Our Ref:- WK/27/117

Re:- Extensions at 5 Cliffe Avenue, Crane Moor, Sheffield.
Reference 2007/1418.

With reference to the above we wish to confirm the following amendments to the proposals.

title PROPOSED DRAWING		
client MR. & MRS. ADDERLEY	date: JULY 2007	scale: 1:50 1:100
project PROPOSED EXTENSION TO : 5, CLIFFE AVENUE, CRANE MOOR, SHEFFIELD.		
job no.: 27-117	drg. no.: 2	rev. C

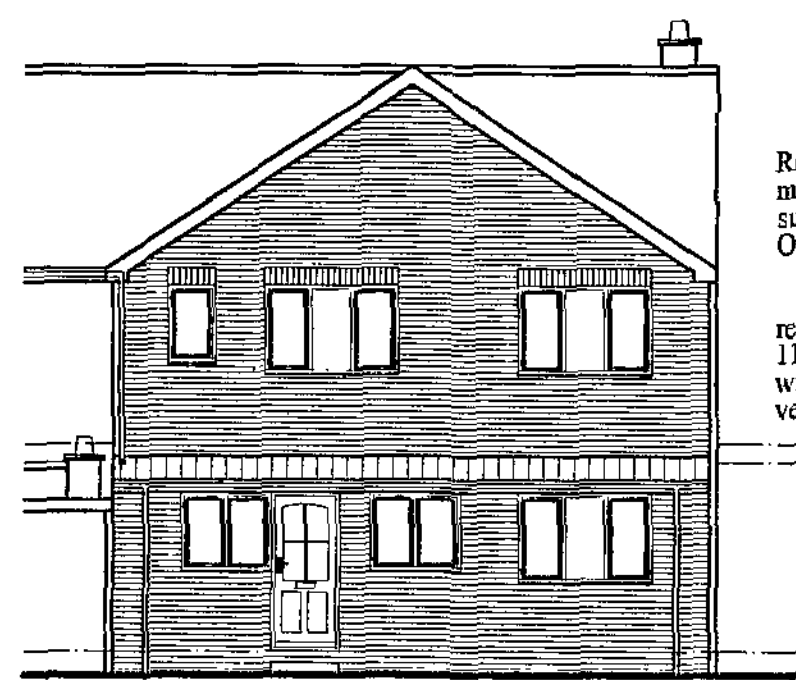
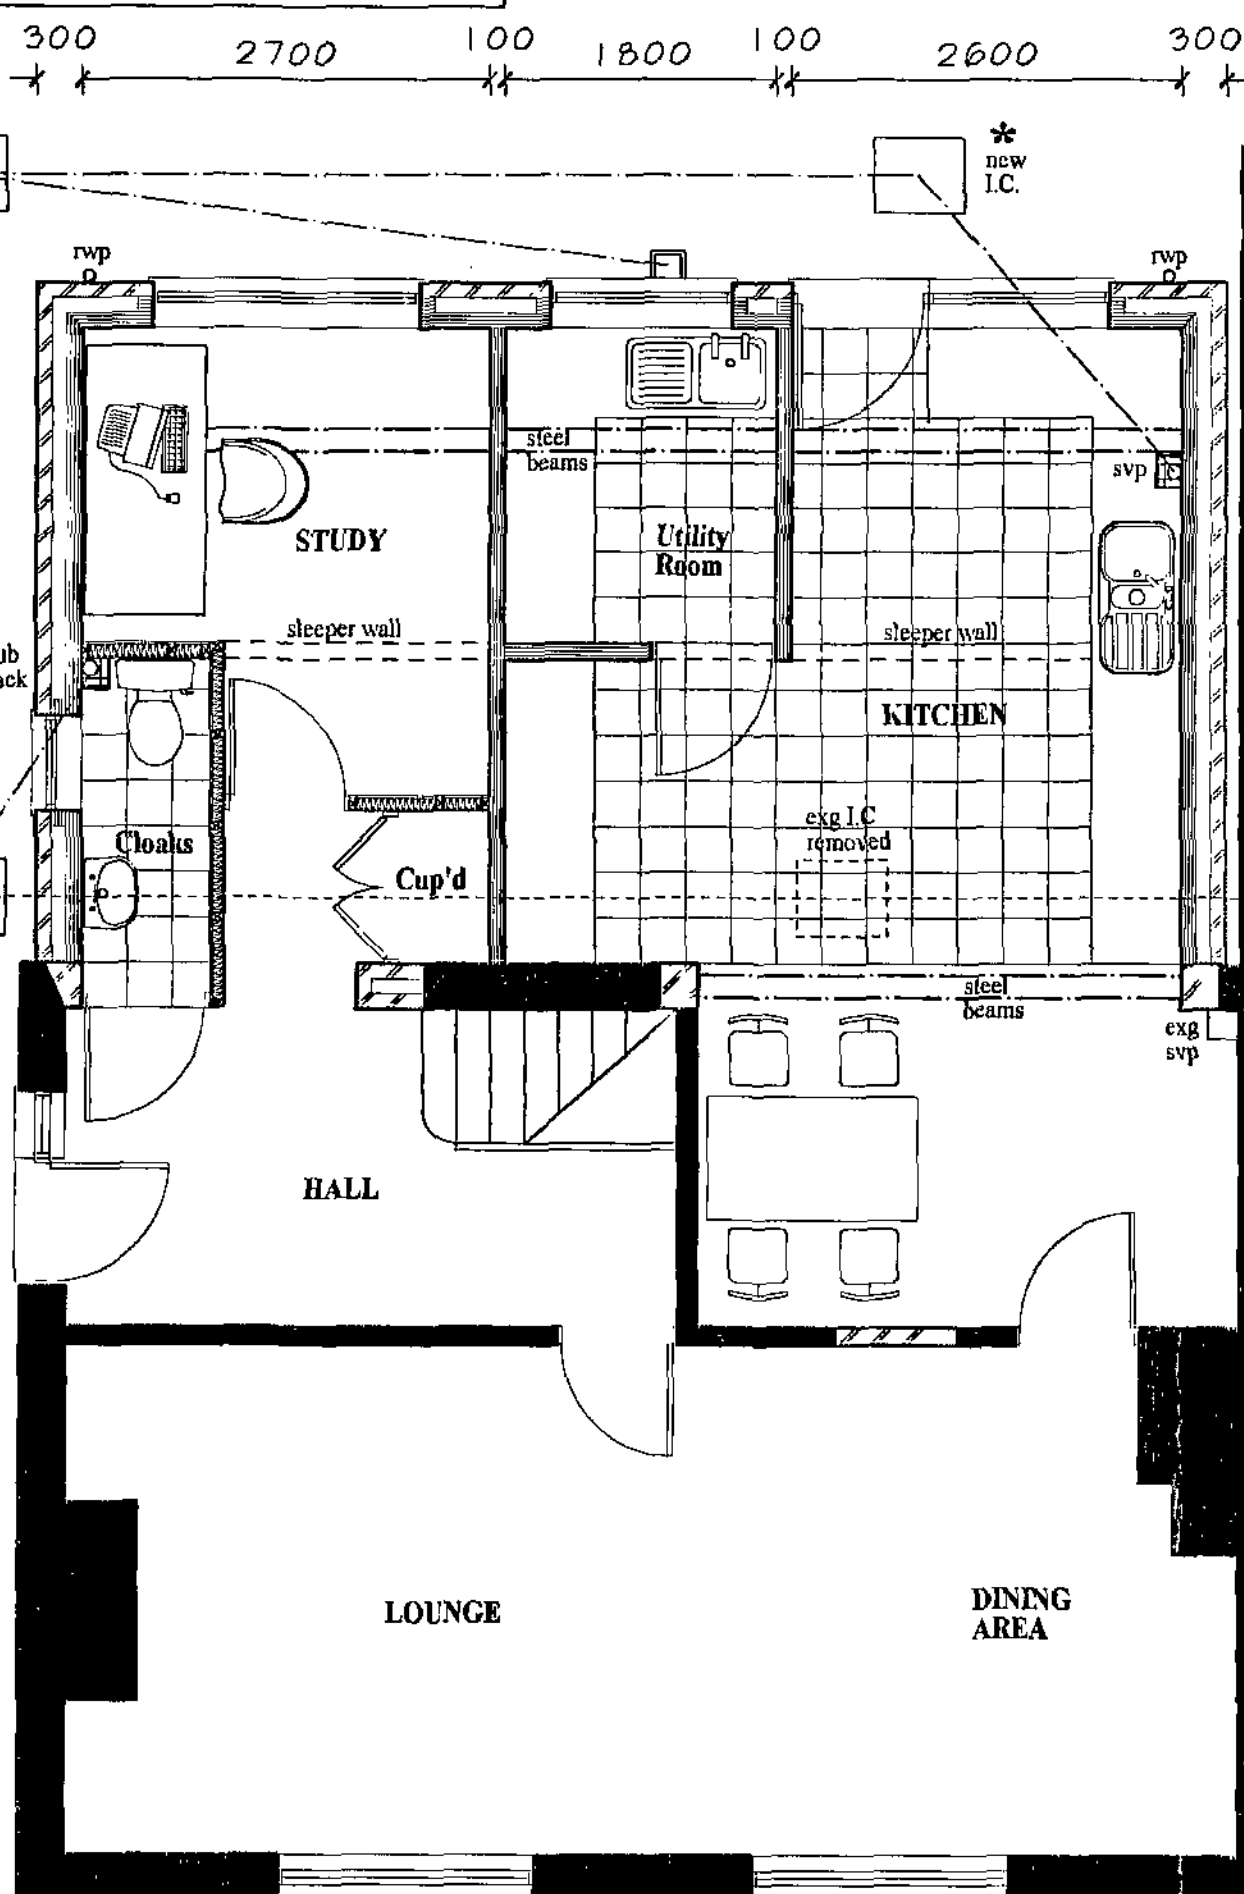
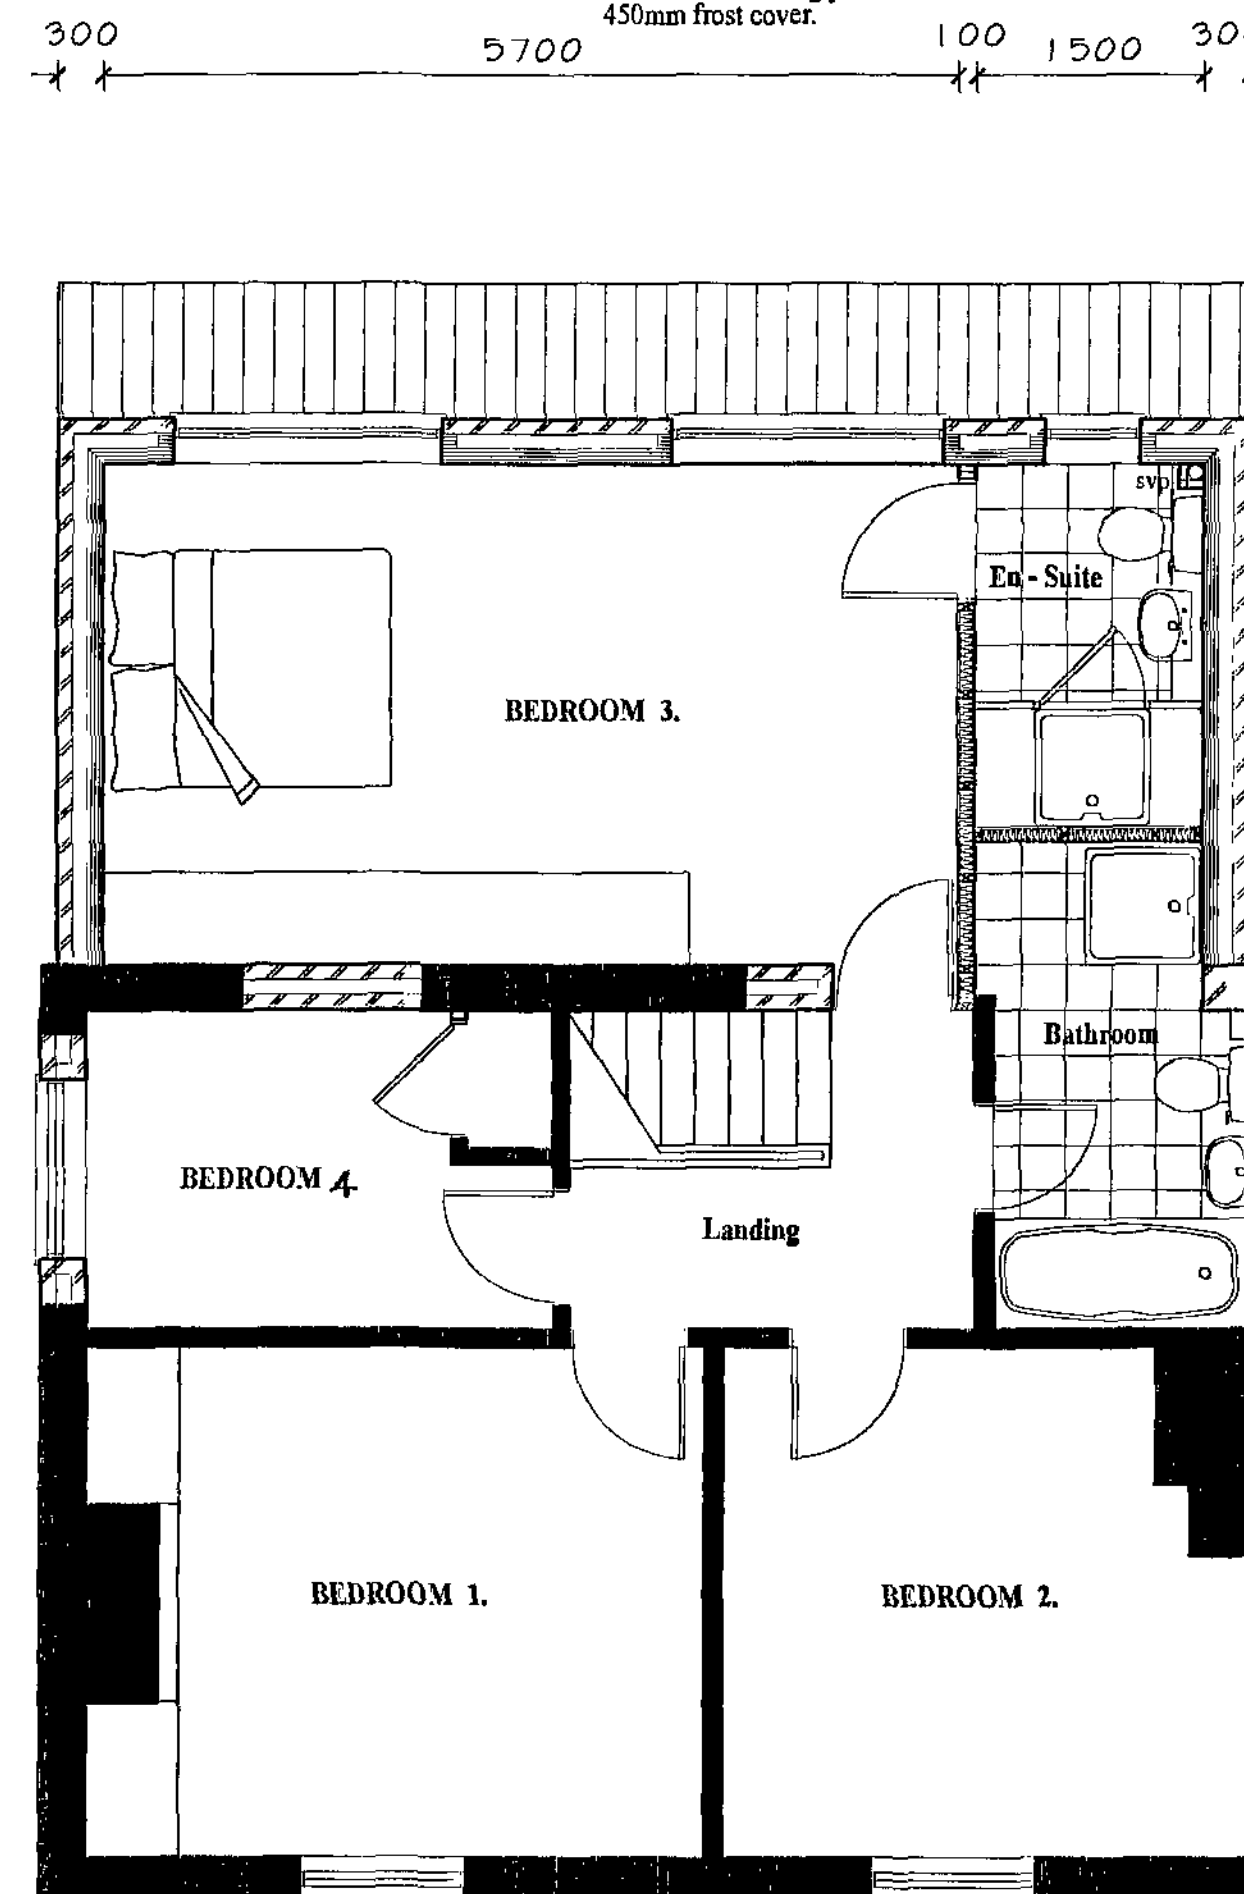
1. *The double doors to the rear bedroom extension have been replaced in favour of a conventional window arrangement.*
2. *The new side window to Bedroom 4 has been shown on the Side Elevation where it was inadvertently missed on the previous drawing.
(It was however shown on the previous plan).*
